**City of Portland
 Development Review Application
 Planning Division Transmittal form**

Application Number: 2012-612 **Application Date:** 10/16/2012 12:00:00
CBL: 045-E-042 *Not under the lowest land CBL*
Project Name: West End Place
Address: 40-44 Pine St. & 183-189 Brackett St.
Project Description: Mixed Use; 39 Residential apartments; 2 ground floor retail suites *eParking*
Zoning: B-1 *G.M. Def*
Other Reviews Required: Historic Preservation
Review Type: Level III Site plan

West End Place – Pine & Brackett Streets
#2012-612 CBL: 45-E-39,40,41,42 & 50
B-1 & R-6 Zones
11/1/2012

Re: Response to Review Comments
West End Place Planning Board Review

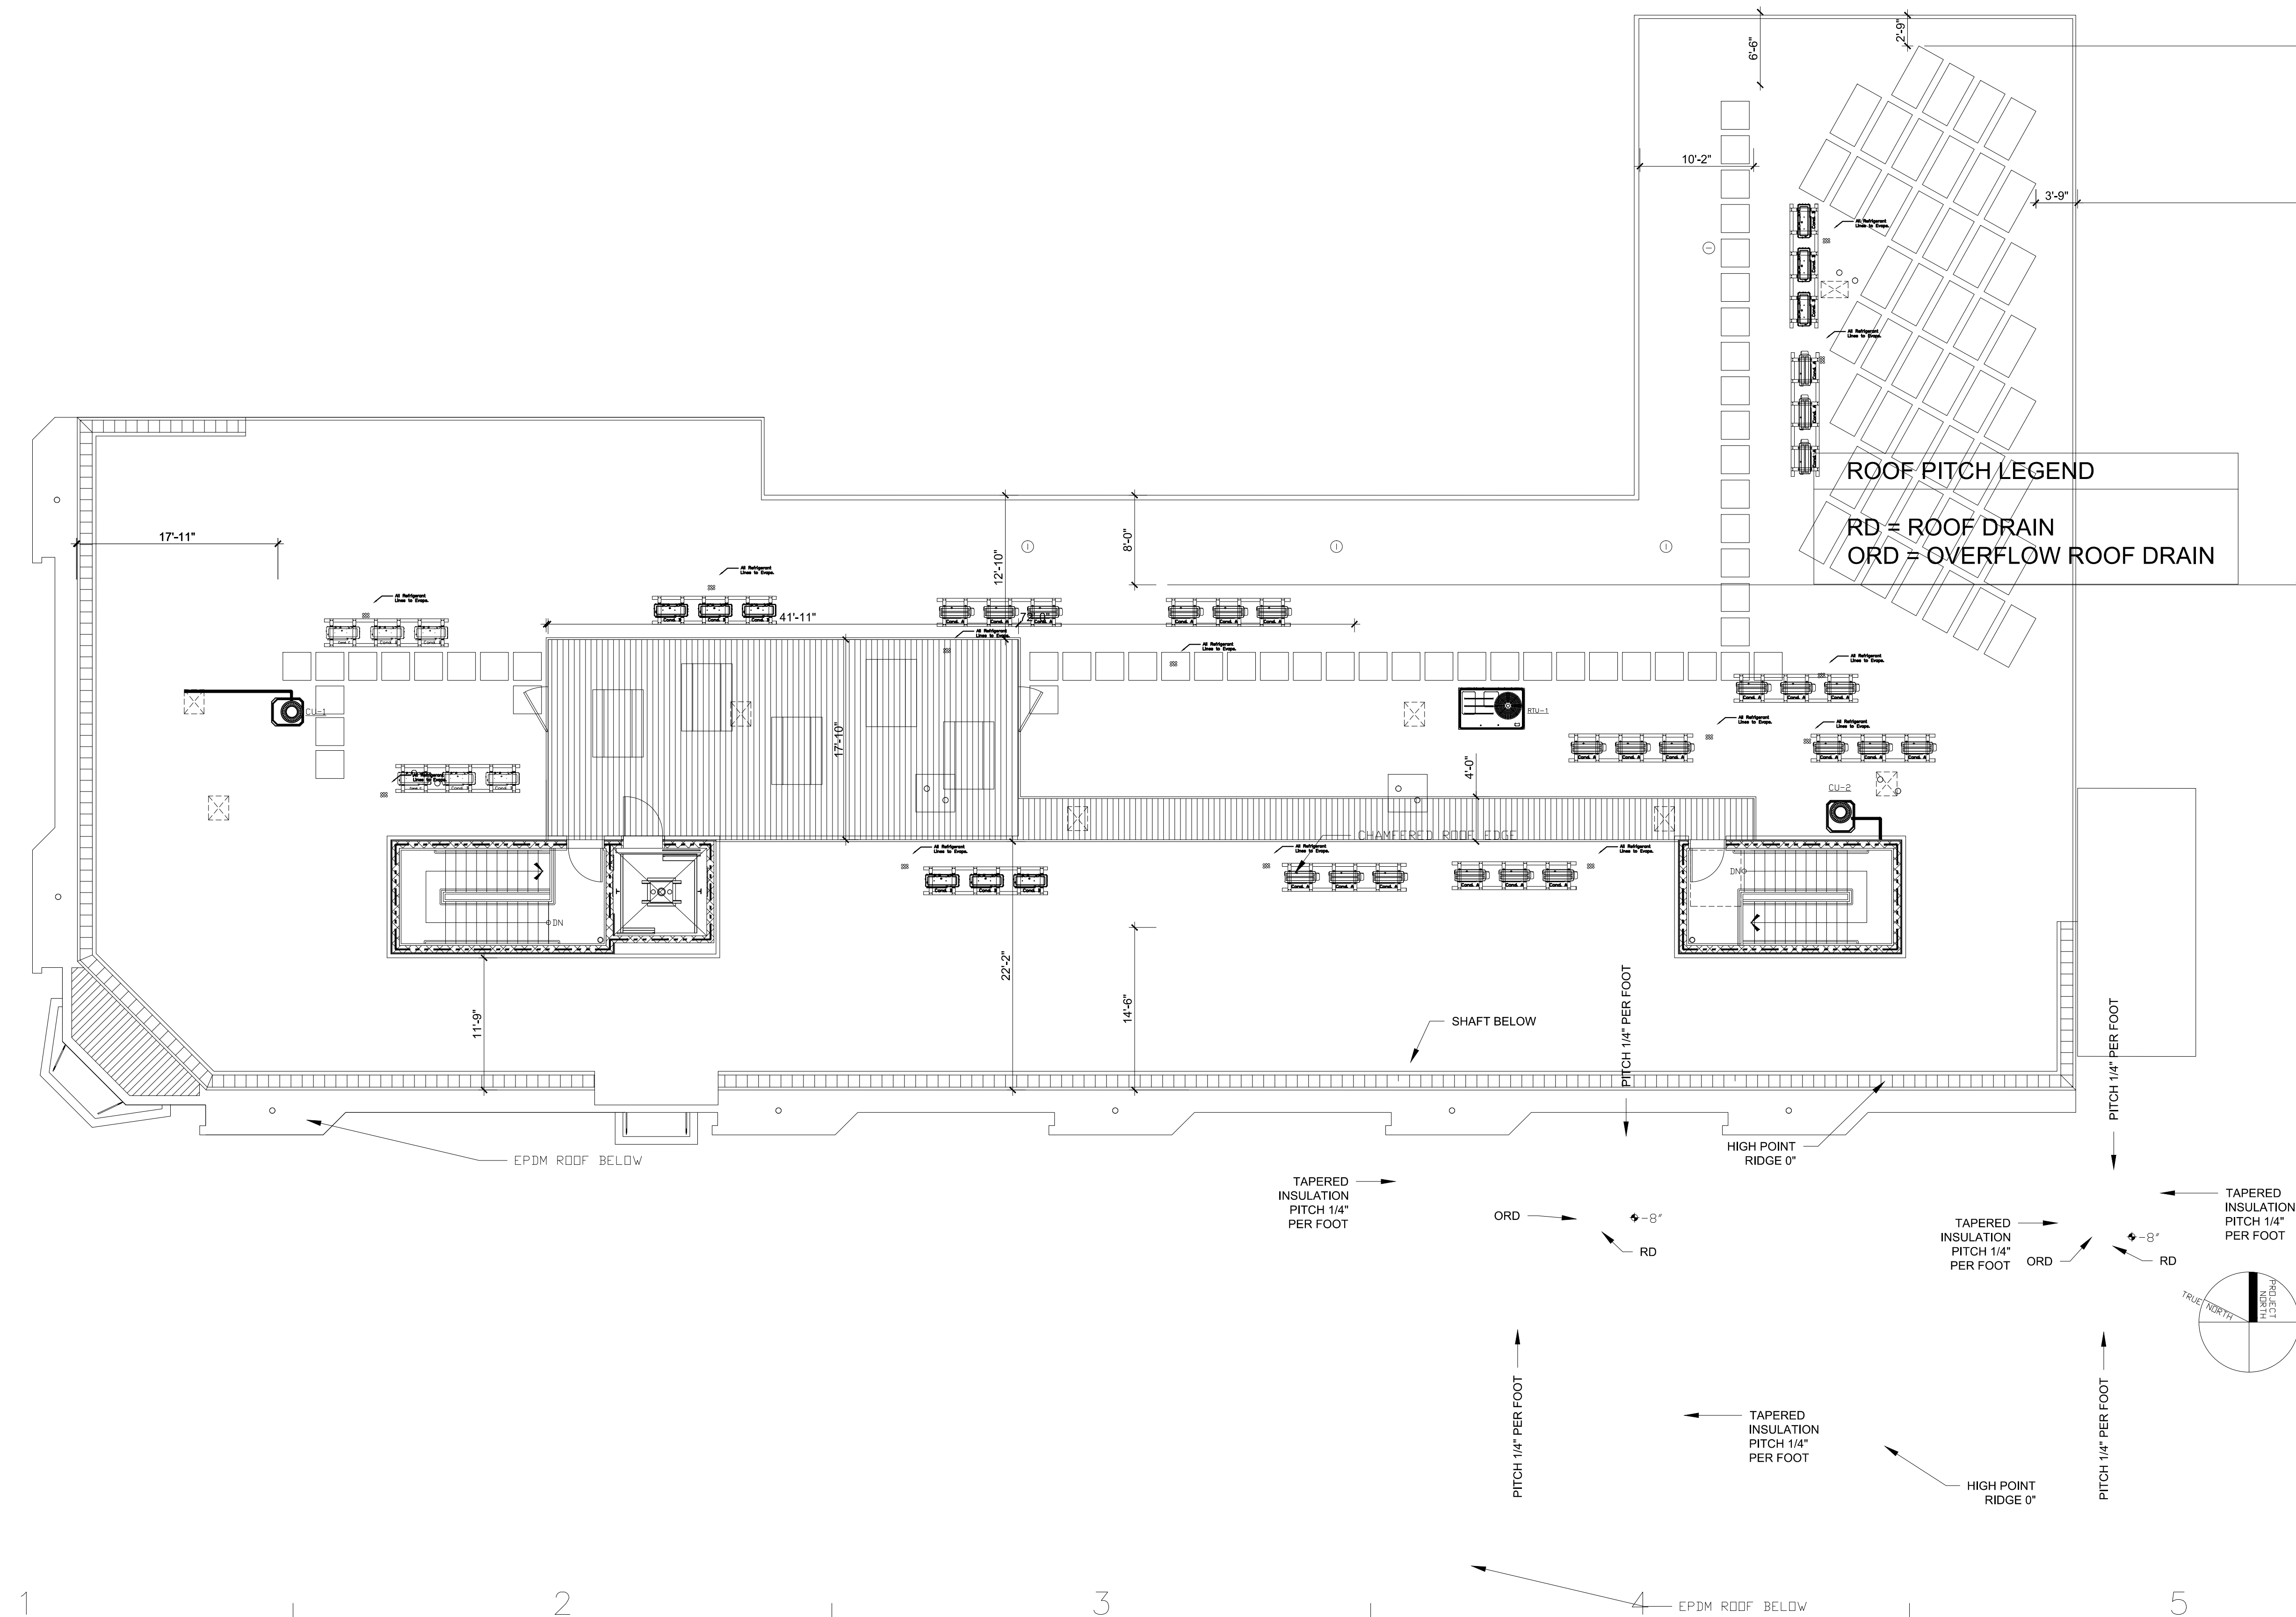
All HVAC units shall meet the maximum noise allowance as stated in the B-1 zone. At the time of HVAC permitting this office will require unit information on dBA emissions.

All HVAC units shall meet the maximum noise allowance as stated in the B-1 zone. At the time of HVAC permitting this office will require unit information on dBA emissions.

Ranor Mechanical forwarded dBA information concerning equipment and their sound data. The bottom line is 52.6 dBAs at 3' from the unit or noise source. The B-1 Zone allows a maximum dBAs of 55. Therefore based on this information, the maximum noise level requirements of the B-1 zone are being met.

Response: The Applicant will submit documentation for all HVAC equipment with their respective dBA emissions when the project is submitted for building permit.

C1-3

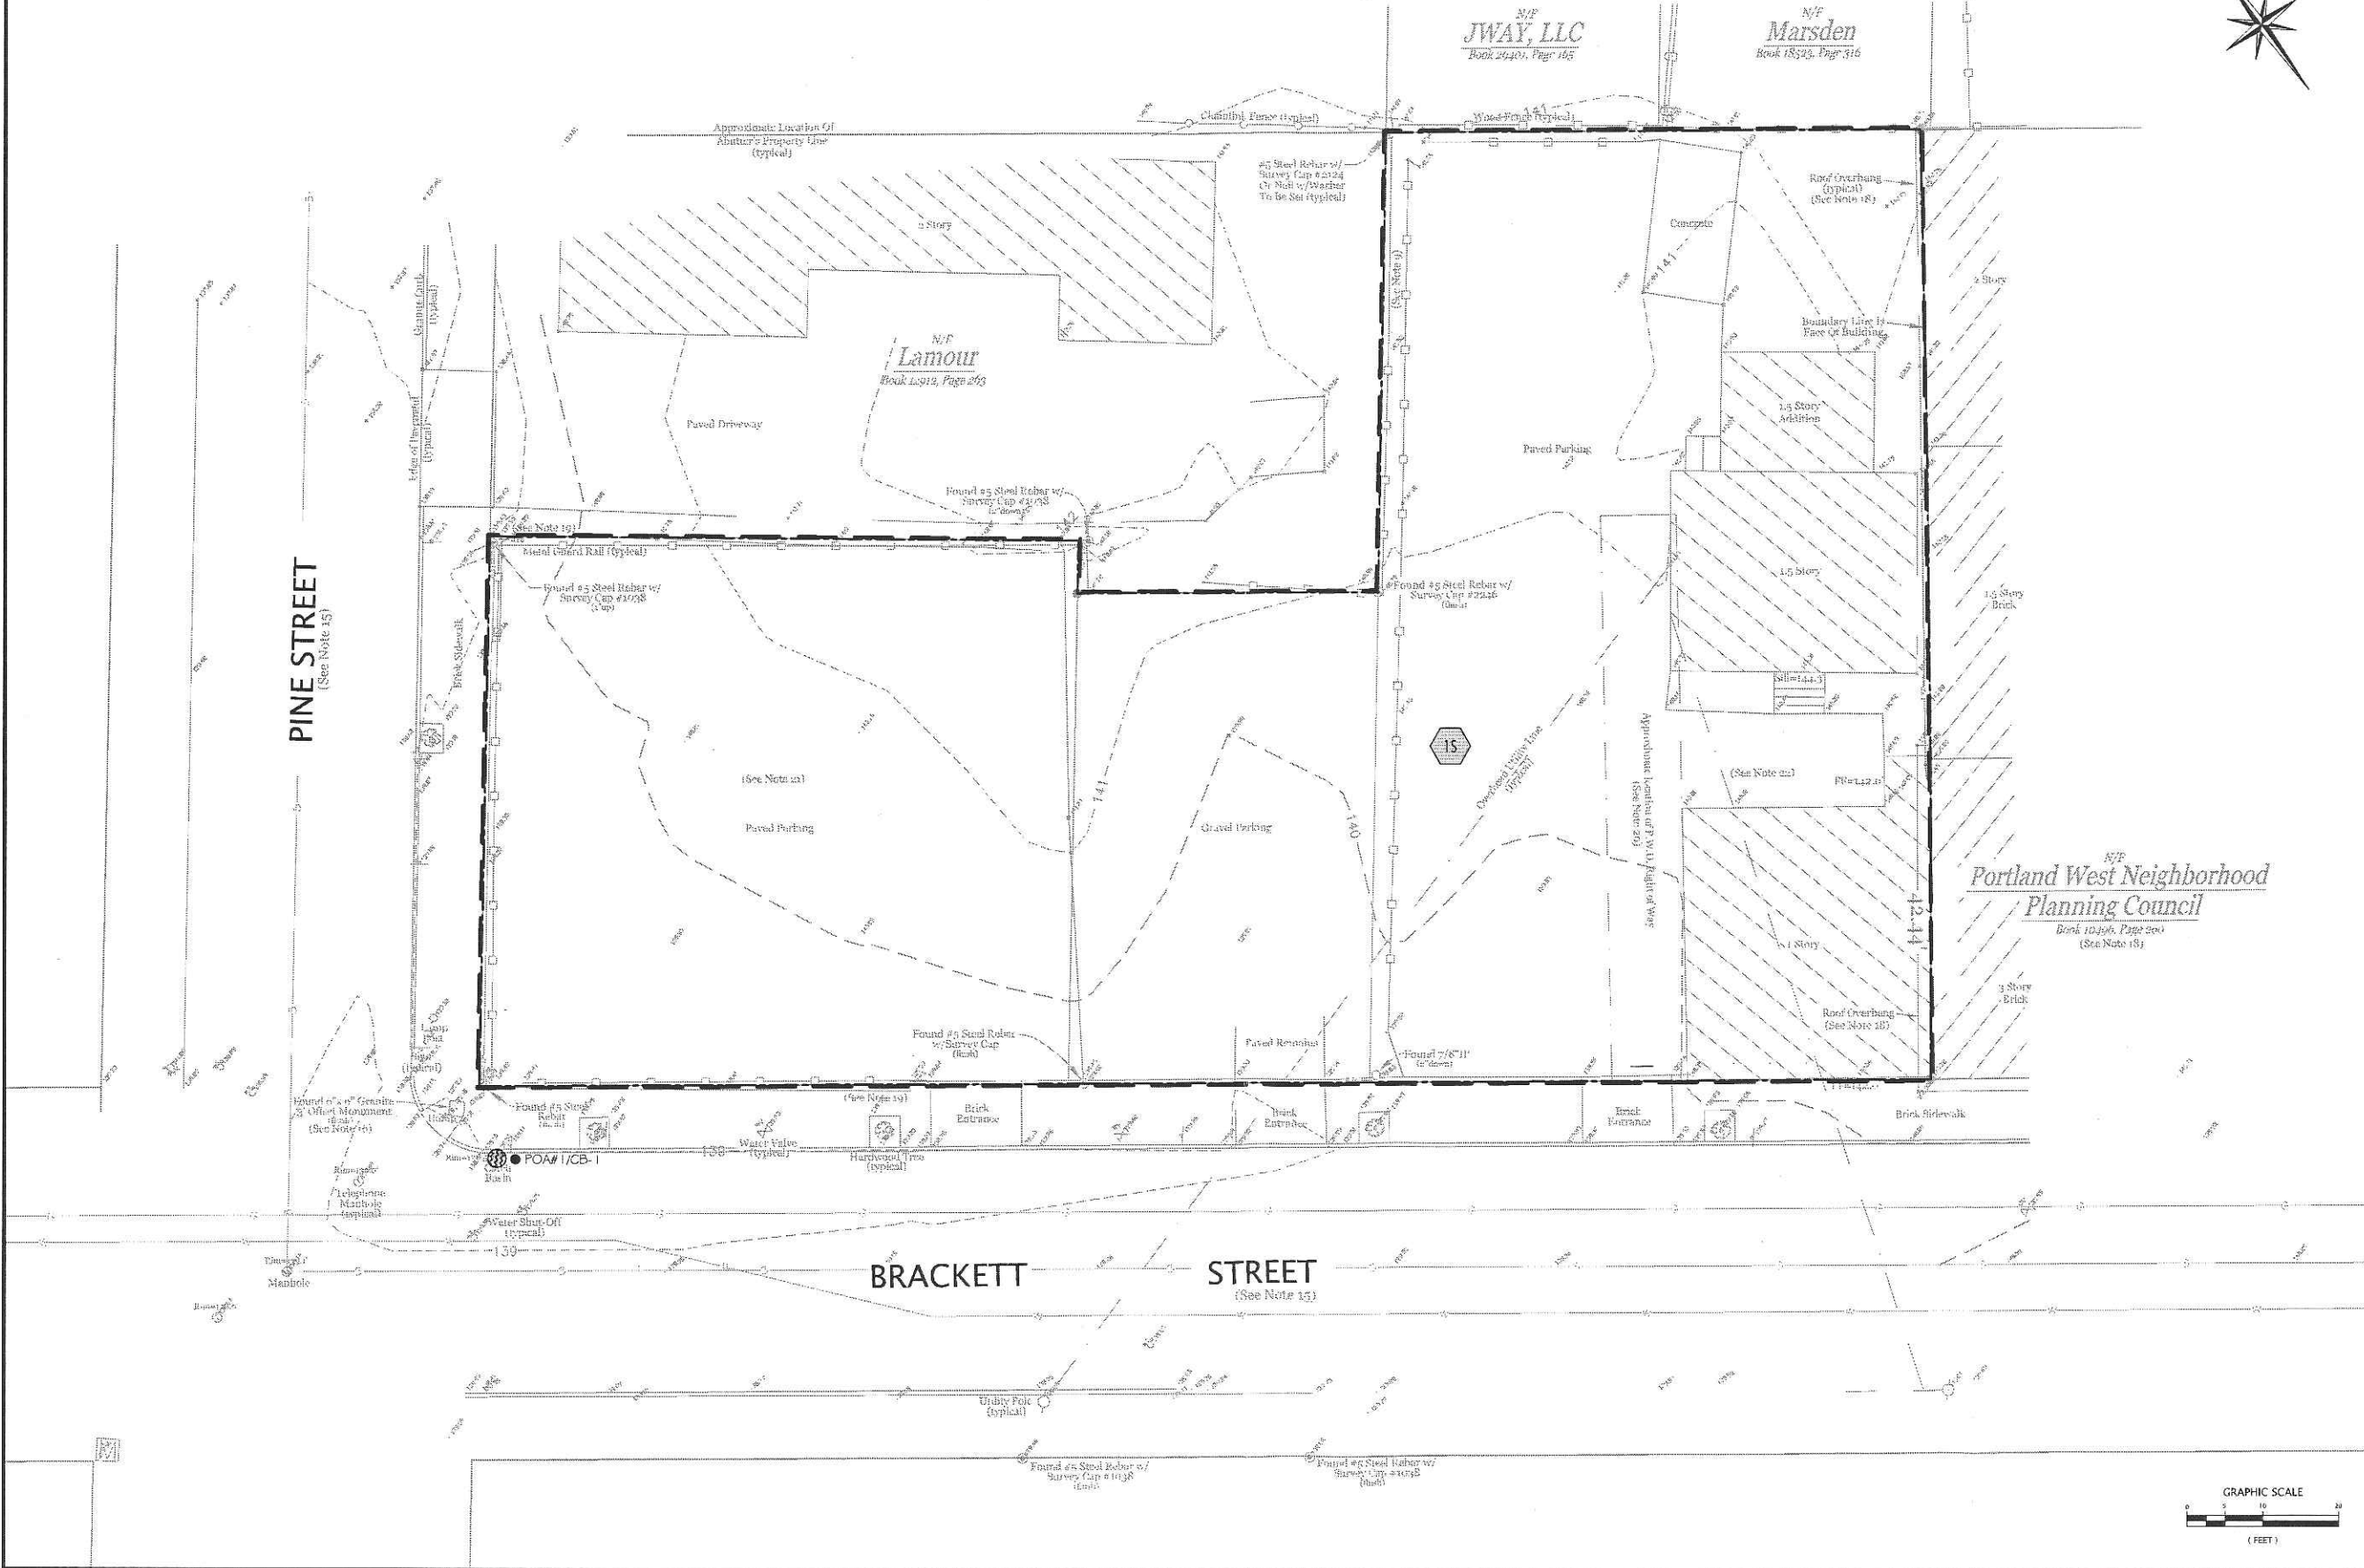
The B-1 zone allows the retail uses and multi-family uses. The setbacks work if Pine Street is declared the "front" of the property. The initial information indicates that the maximum building height can be met. However, I would like more detail showing the average grades around the building and how that relates to the height. The maximum impervious surface ratio is being met.

Response: Pine Street is the Front of the Property. See the Grading Plan (Sheet C1-3) Indicating Spot Grades around the Building. The base floor elevation is 139.40', the building height of 43'-0" from top of roof beam of the proposed structure is measured from this elevation. The lowest grade at the face of building perimeter is 139.0'. At one location on the Northwest corner of the building, grades increase in all directions around the perimeter. The average grade will be higher than or equal to 139.40' and the building height of 43'-0" to top of roof beam from 139.40' will be below the 45' maximum for the Zone.
